**Minto Resource Recovery Facility (SSD-5339)
Request for additional information**

I refer to Response to Submissions for the Minto Resource Recovery Facility (SSD-5339). The Department has reviewed the information and notes that there are still matters to be addressed.

Attachment 1 – Department's comments

DRAWING TITLE				
SWEPT PATH ANALYSIS - SHEET 2 TURNING MANOEUVRE ON SITE				
PROJECT NO.	PLANSET NO.	RELEASE NO.	DRAWING NO.	REVISION
P1203464	PS02	R15	PS02-DZ02	H

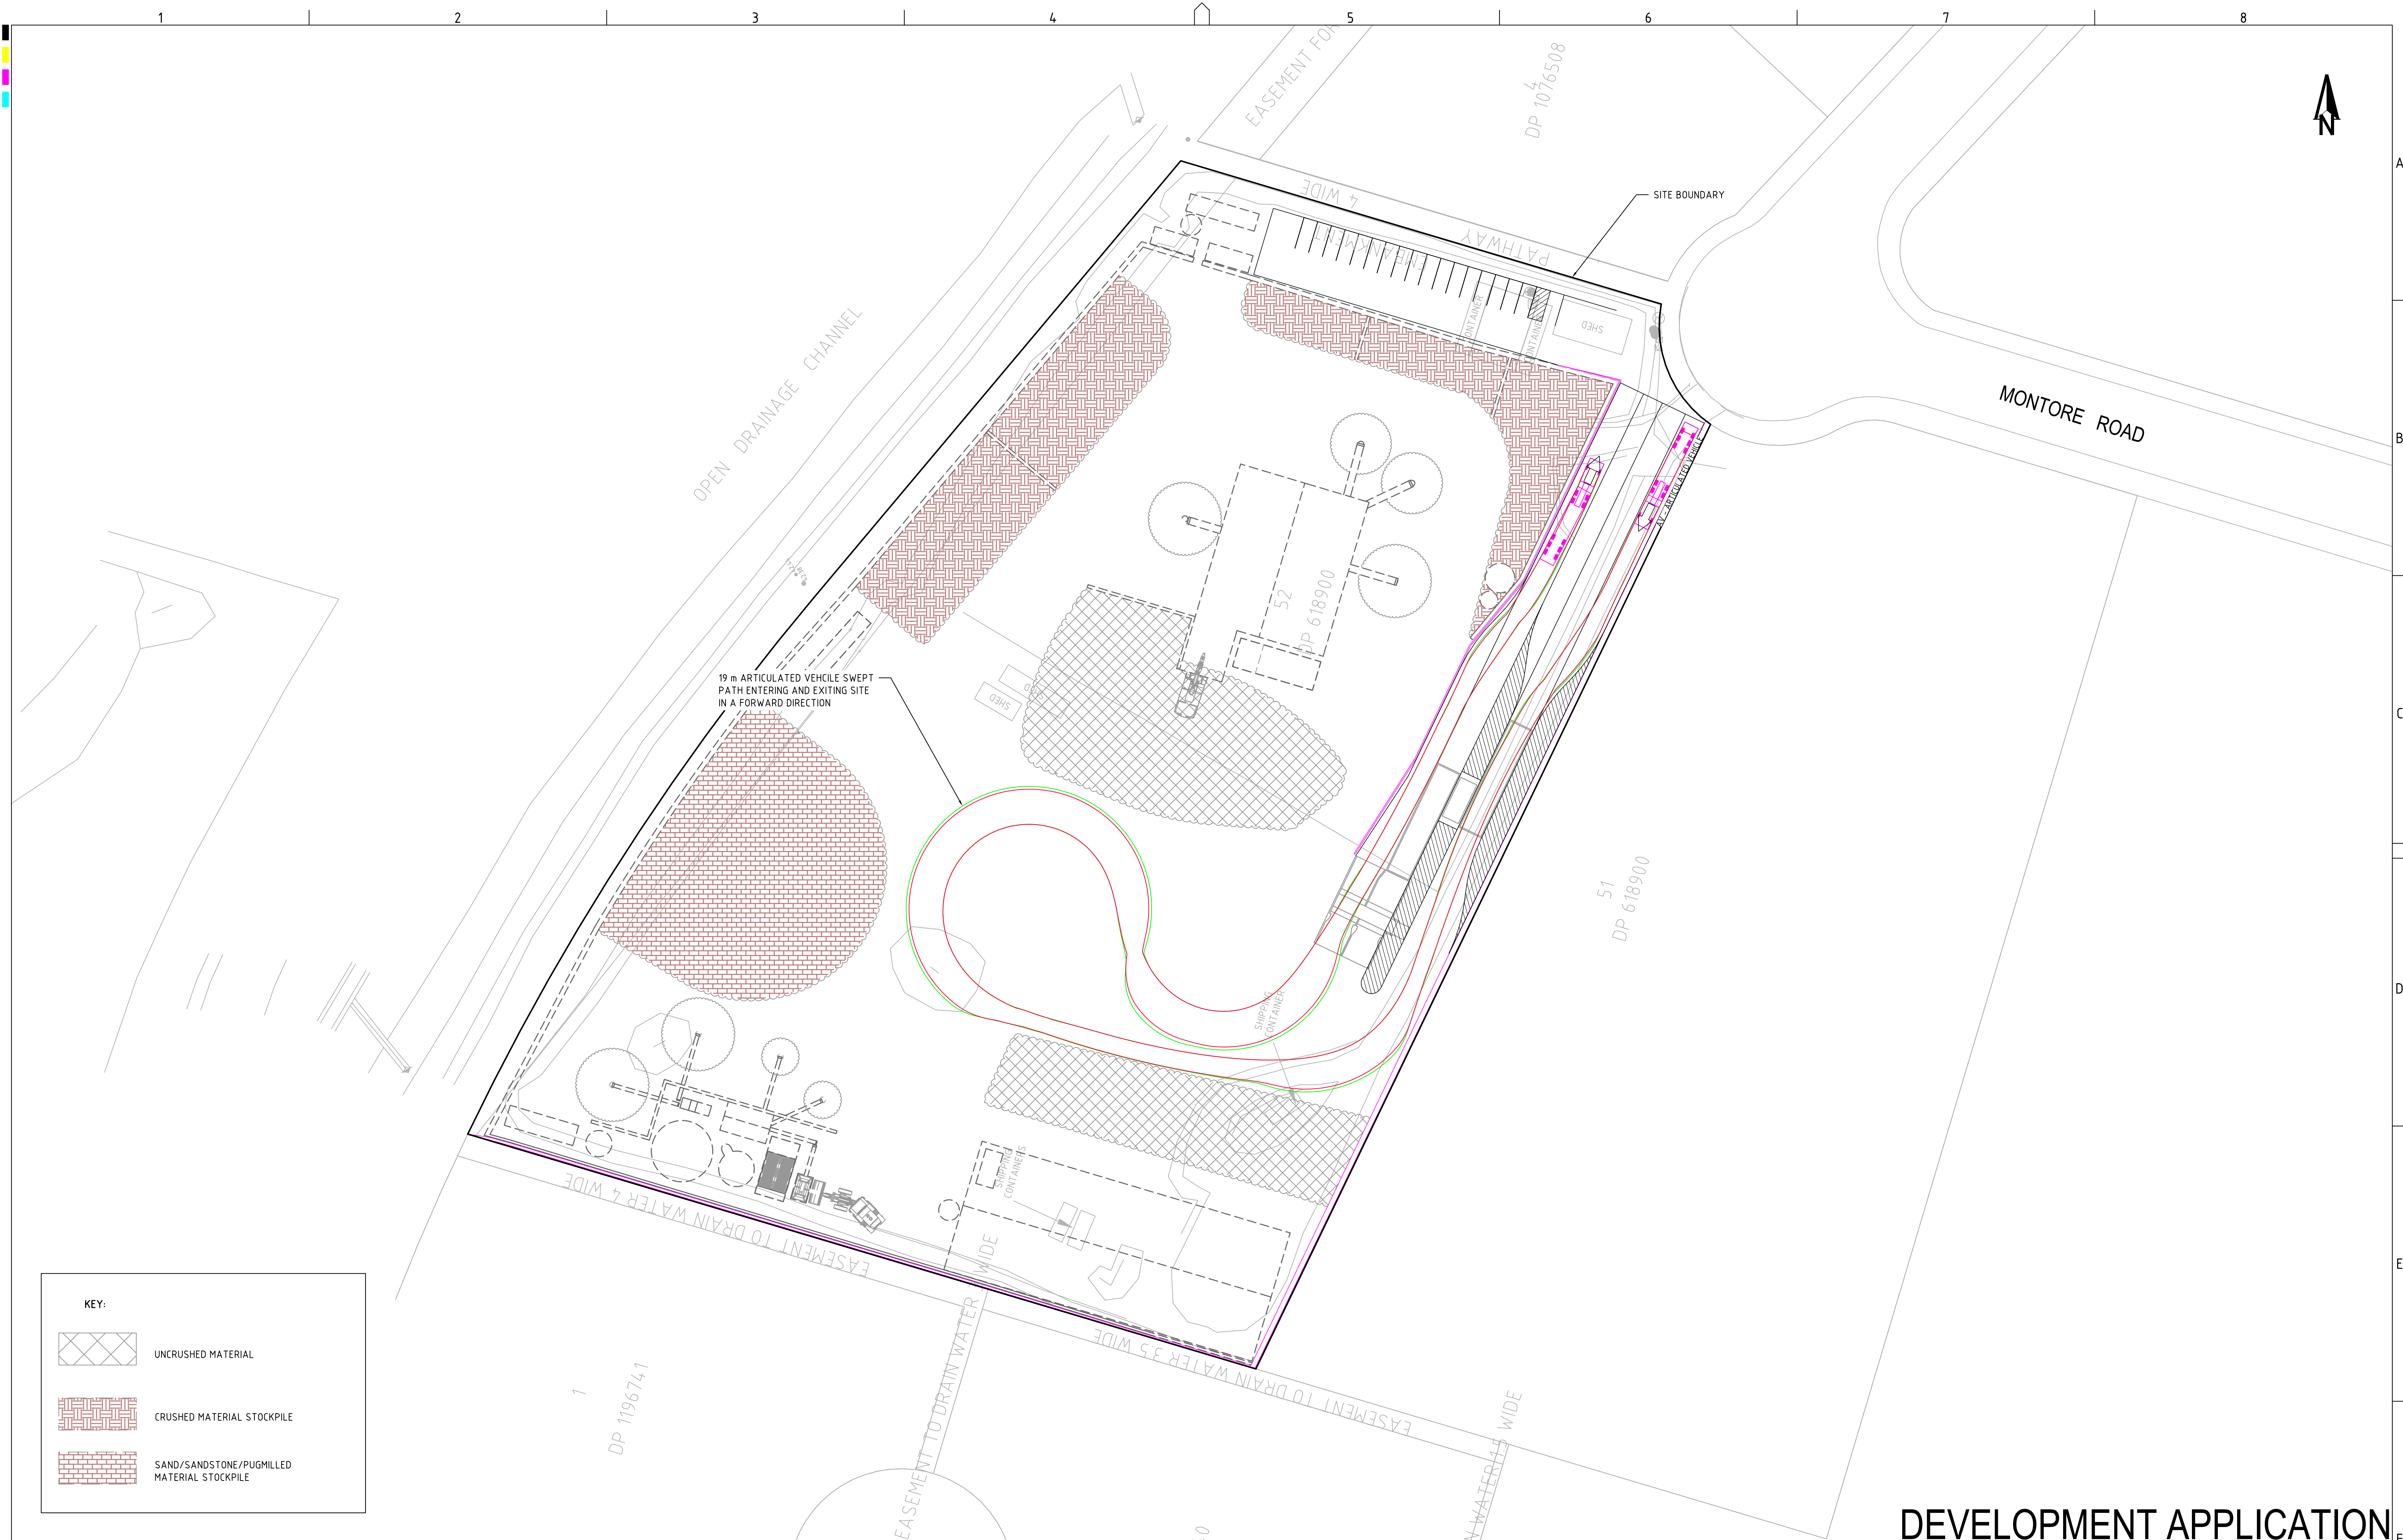
- The swept path diagrams indicate that a truck cannot exit the site if a truck is entering and vice versa, please describe how these movements would be managed onsite. A sign only is not sufficient.

- Explain why the swept paths, particularly those shown entering and exiting the site, in Attachment 9 are different to those in Drawing 2021-276-03B in appendix 12 and which one is accurate.
